Deadline 1 submission – from James Hewitt

This submission questions the area of land-take proposed and what an approved DCO would entitle the Applicant to do.

EXTENDED CROSSNESS LOCAL NATURE RESERVE PLAN: 2.9

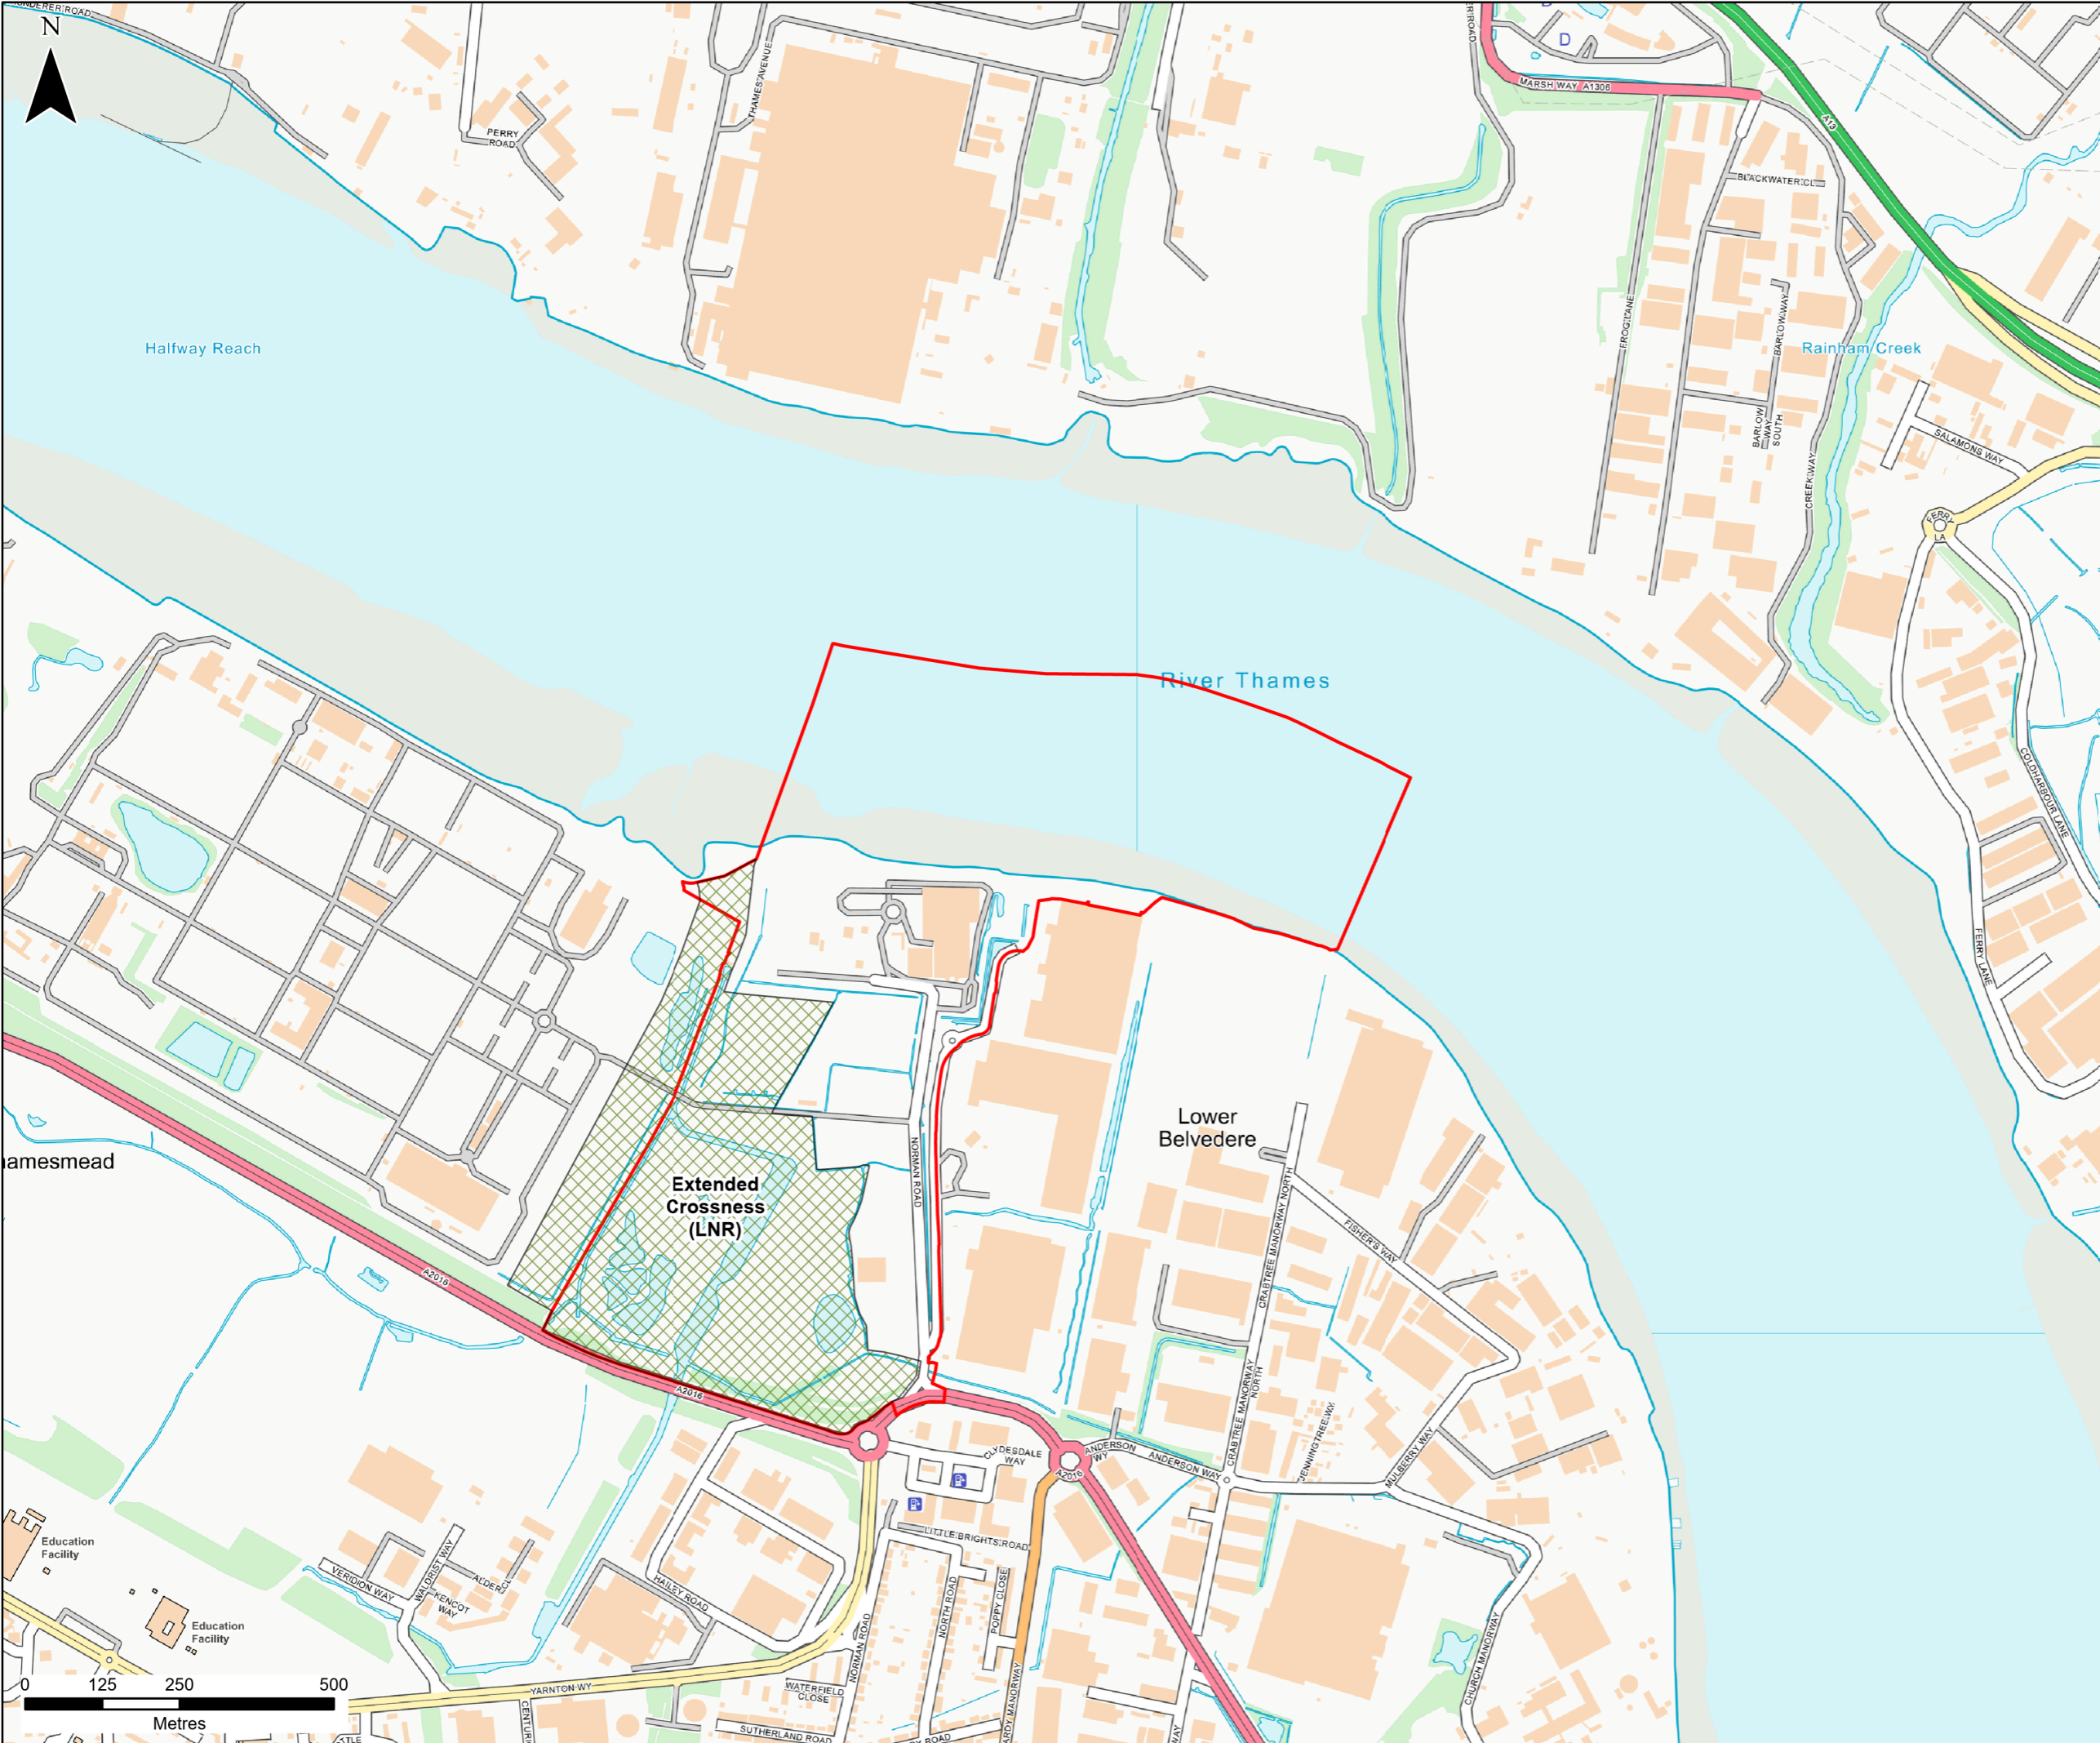
1 - Further to the hearings between the 5th and 7th of November, the following chart reinforces the view that the land-take sought by the Applicant is well in excess of need. If the proposed project were to capture 1.7 million tonnes of CO₂ in a year [see Note 1 below], the chart indicates that the land take required is unlikely to exceed three hectares – less than half the eight hectares which the Applicant asserts is needed (Clause 6.6.2 in “*Statement of Reasons*”). §

2.1 - Obtaining Nationally Significant Infrastructure status may serve to facilitate land acquisition by the Applicant, especially parts of Crossness Nature Reserve and its buffer zones - which might not otherwise be available. Subject to the content of the proposed DCO (as indicated in clause 4.5.1 of the “*Statement of Reasons*”), the Applicant may be under no obligation to proceed with the proposal and may opt instead to profit by developing the land acquired or from its disposal to others not bound by the DCO. §
